Our reference: ECM: 9476817  
Contact: Gavin Cherry  
Telephone: (02) 4732 8125

19 March 2021

**Response to Request for Advice on Oakdale West Estate Stage 3 Development  
SSD 9794683**

1 ELEVATION WEST - WAREHOUSE 2C 1 : 250

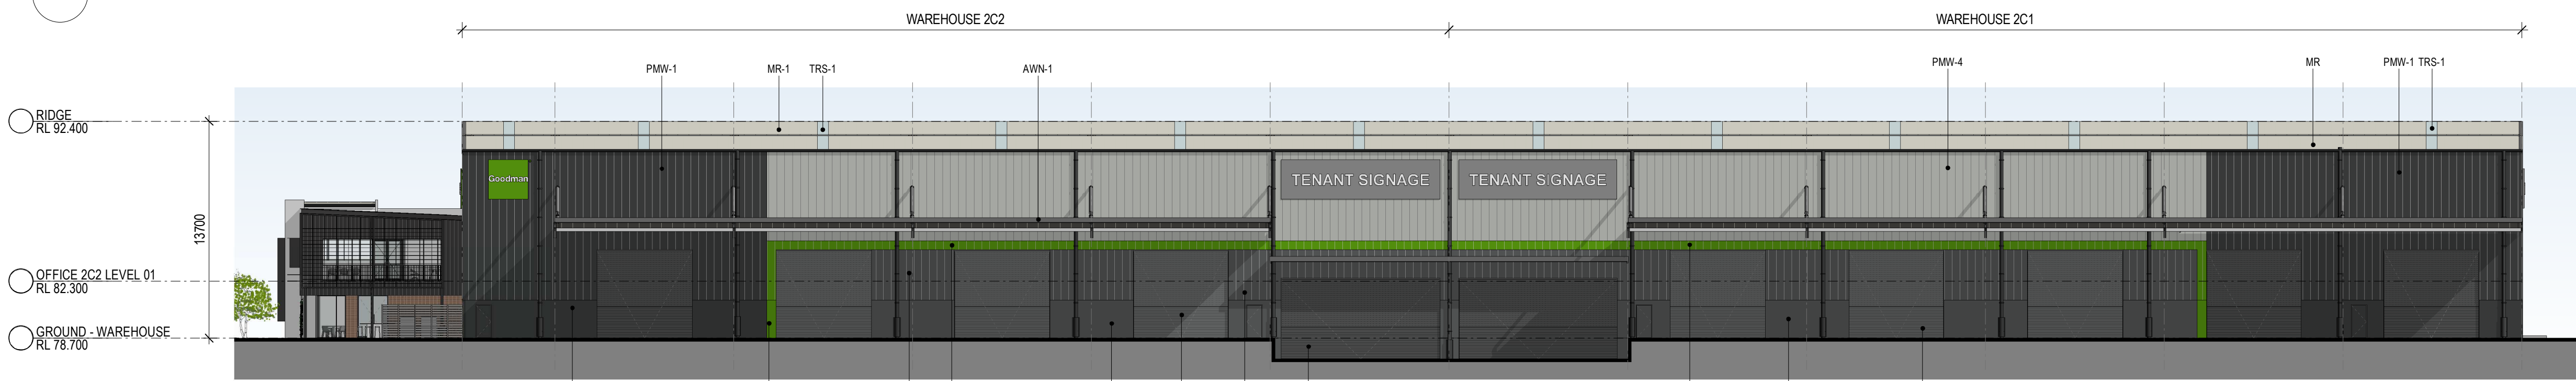
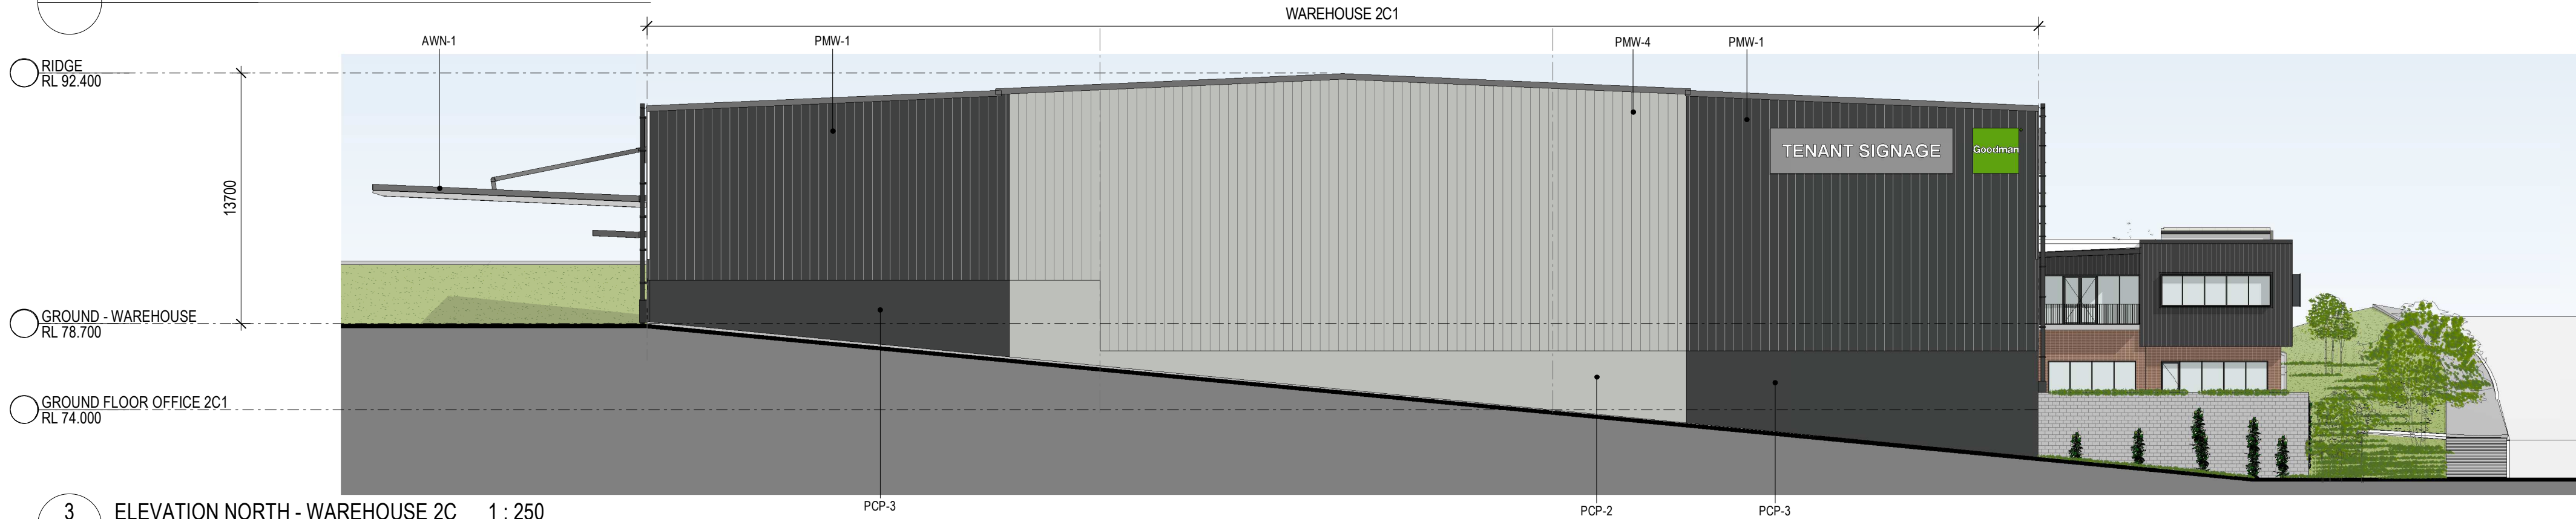
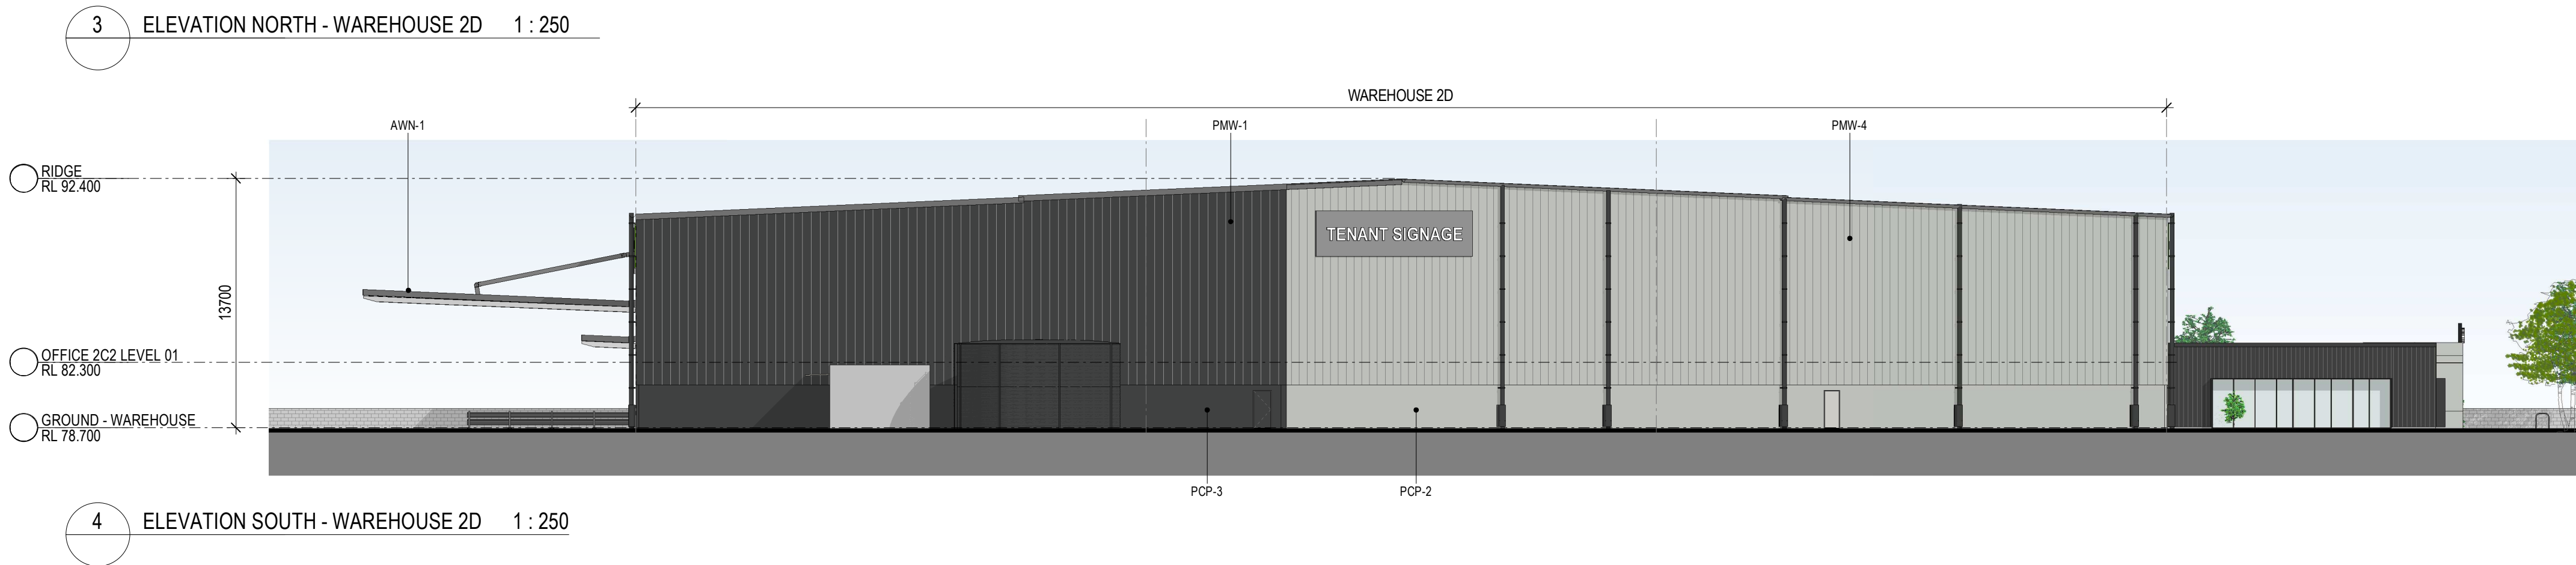
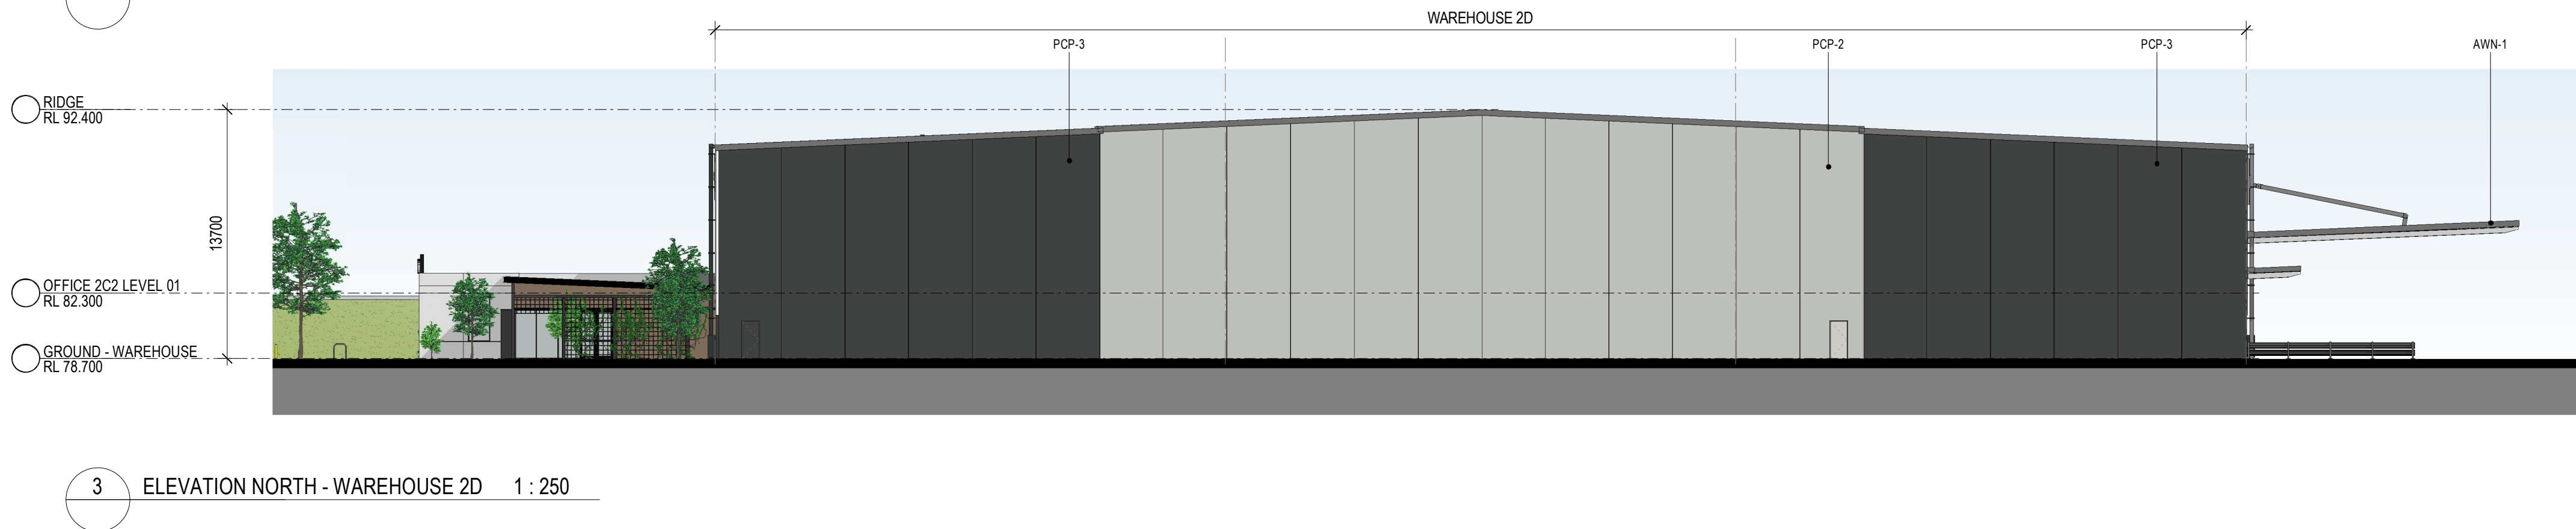
- Warehouse Lot 2C: The proposed arrangement and building form is not supportable as the design has not been sufficiently addressed visual prominence. The Statement suggests that the building is less than 15m in height to the ridge however the effective height of the building must be measured from existing ground level which when taken from the kerb line in the road presents visually as a 22.2m building. Elevation West – Warehouse 2C and Elevation North – Warehouse 2C best reflect the extent of exposed fill, retaining walls and height above the road level and above the adjacent development to the north being Amazon. This is an unsympathetic response to a challenging topographic fall through the site, which appears to be a cross fall of approximately 11m. The topography requires a stepped building form, with finished floor levels that are far more responsive to the ground level and development interface at the northern boundary of the lot. The exposed bulk and presentation of walls resulting from fill is emphasised due to inadequate landscape setbacks between the driveway and northern boundary which will not be able to ameliorate the visual impact of this wall from the roadway or from the adjacent development to the north. The issue arises from the adoption of the same finished slab level (RL78.70) between Warehouse 2C2 and 2C3.

It is considered imperative that the building form provide a split slab, lowering the finished floor level and building height above ground level of Warehouse 2C-1 to respect the topographic fall of the site. This will require changes to floor plan arrangements, internal manoeuvring, parking arrangements and driveway ramping.. If the stepped slab and revised manoeuvring cannot be achieved, then
